City of Portland, Maine - Building or Use Permit Application

Permit No: 05-0369	Issue: PERMIT ISSUED APR 19 2005 081 B01100
-----------------------	--

Proposed Project Description:
Change of use from two family to single family with home occupation (Lawyer's Office)

Basement sketch:

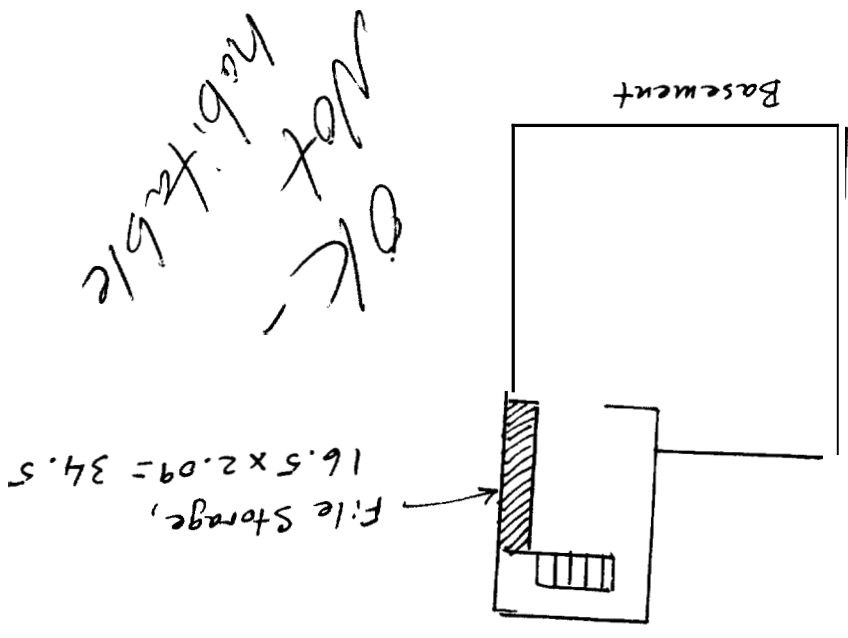
- 1) The basement is NOT approved as habitable space. File storage only. A code compliant 2nd means of egress must be installed in order to change the use of this space.
- 2) This is a Change of Use ONLY permit. It does NOT authorize any construction activities.
- 3) Separate permits are required for any electrical, plumbing, or heating.
- 4) Separate Permits shall be required for any new signage.
